Description: 2 storey extension & new garage

Amendment: Revised side/rear fenestrations, addition of chimney & alts.
to garage. (Dwgs. 2001/3/3REV.D; /4REV.D & /5REV.C1)

**TOWN AND COUNTRY PLANNING ACT 1990
NOTICE OF ACCEPTANCE OF AMENDMENT**

Re: Extension to Hillgate Farm, 61 Station Road, Gedney Hill
Planning ref: HO7/1436/01

PROPOSED TWO STOREY EXTENSION
STATION ROAD, GEDNEY HILL,
FOR MR AND MRS WARNER
Proposed Ground Floor Plan - scale 1:50
KAREN BRADLEY - CHARTERED ARCHITECT
Dwg. no. 2001/3/3 REV D (JUNE 2003)

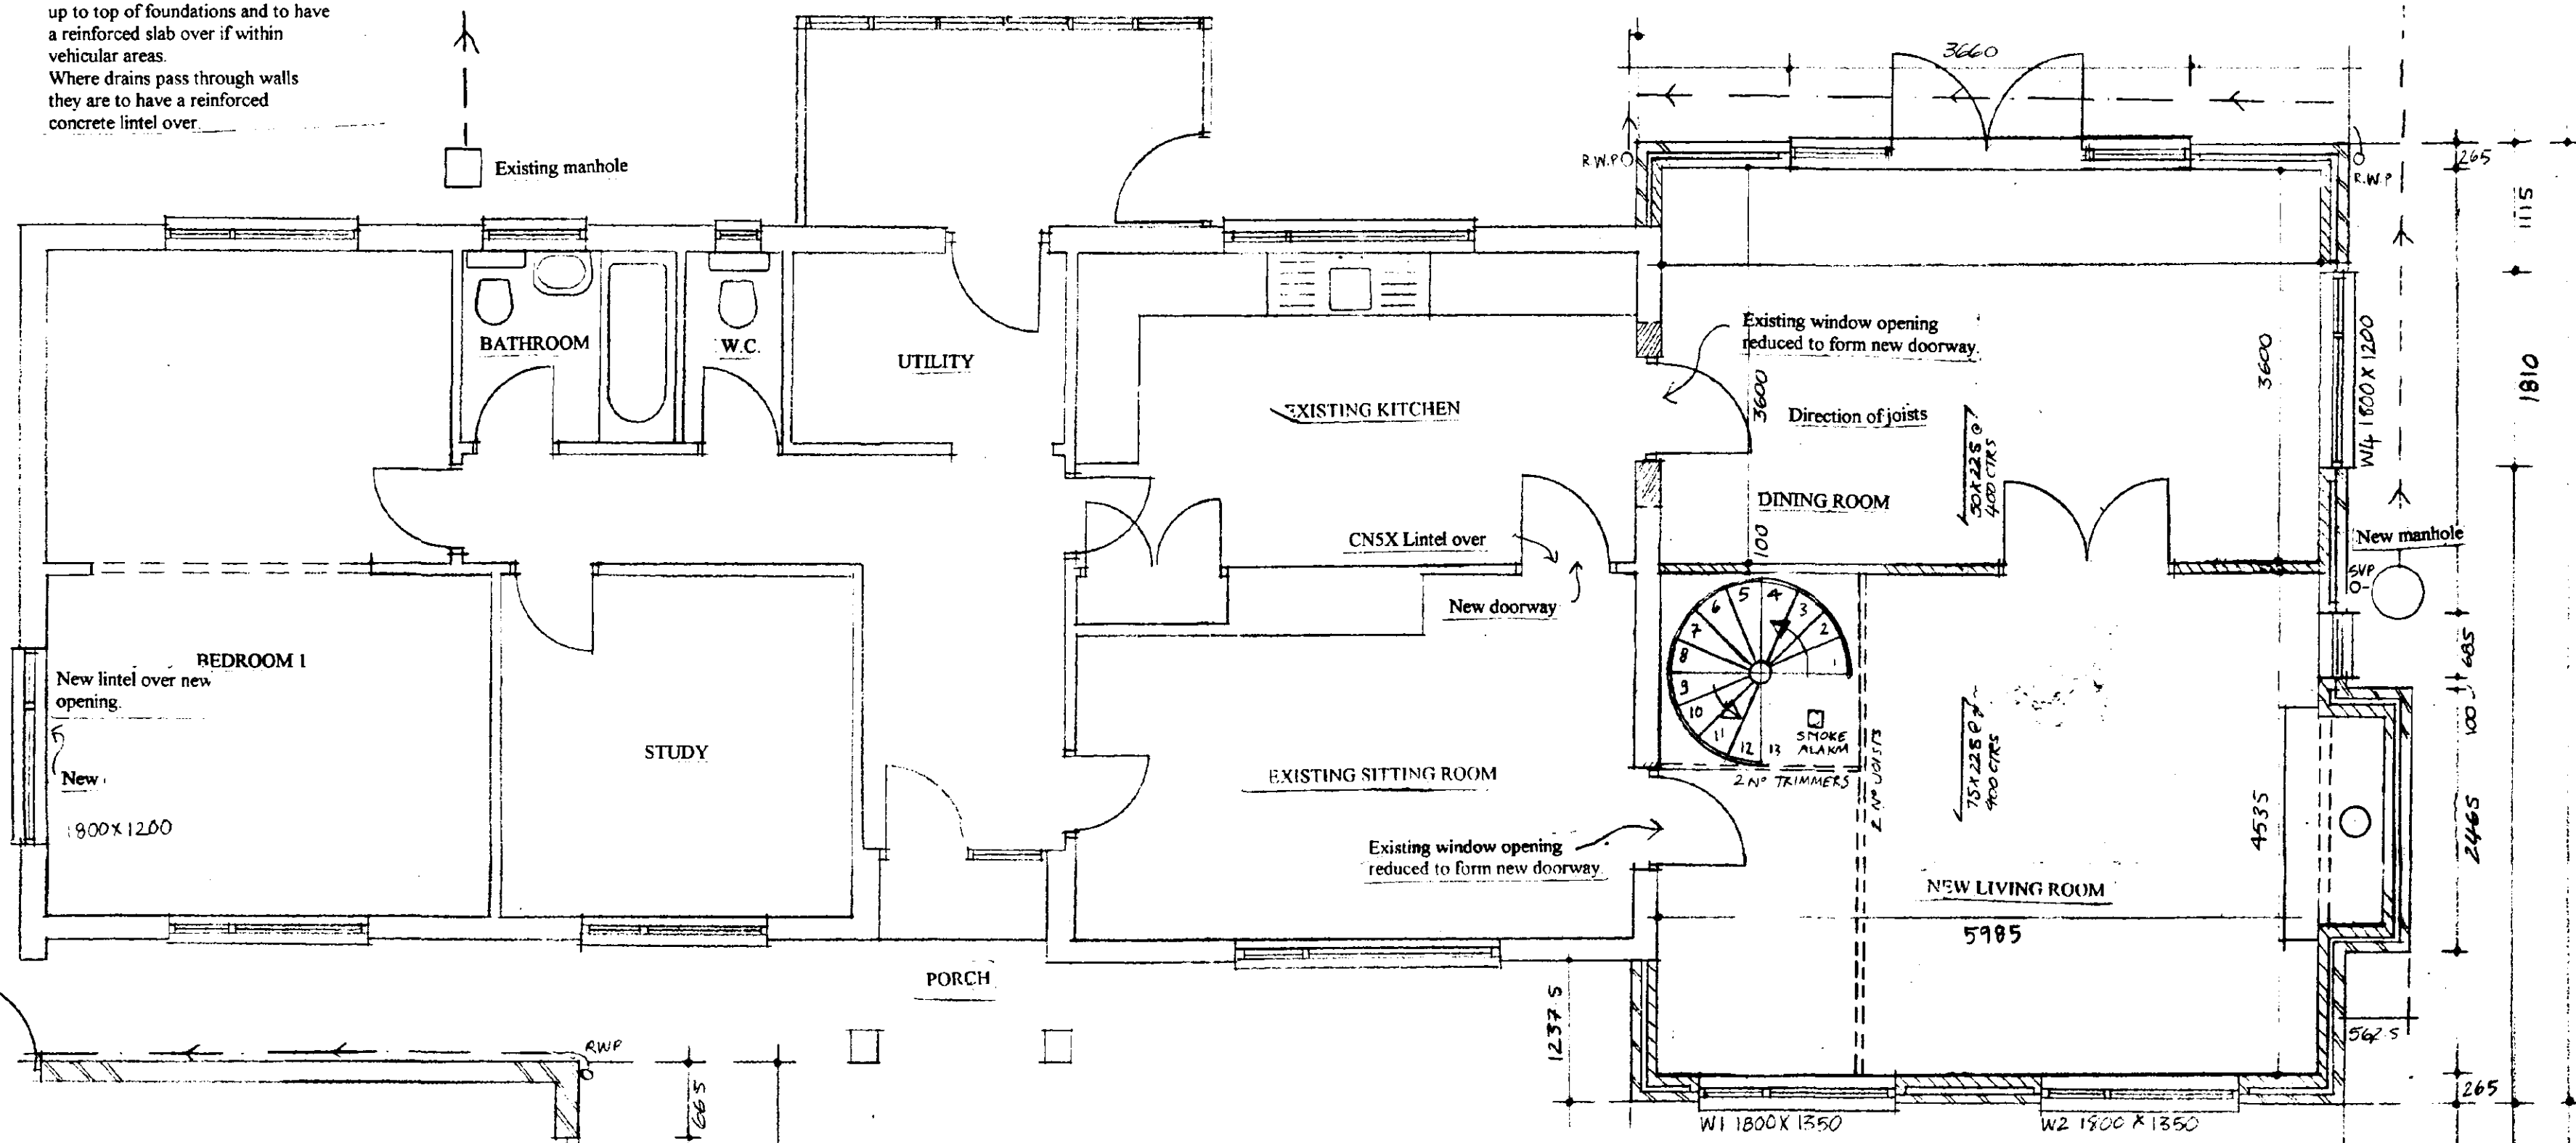
Please find enclosed revised drawings in respect of the above, in which you will see that there are a few amendments, firstly to the side and rear fenestration, secondly a chimney has been added. Thirdly, the garage is now a single garage with boarding to the top.
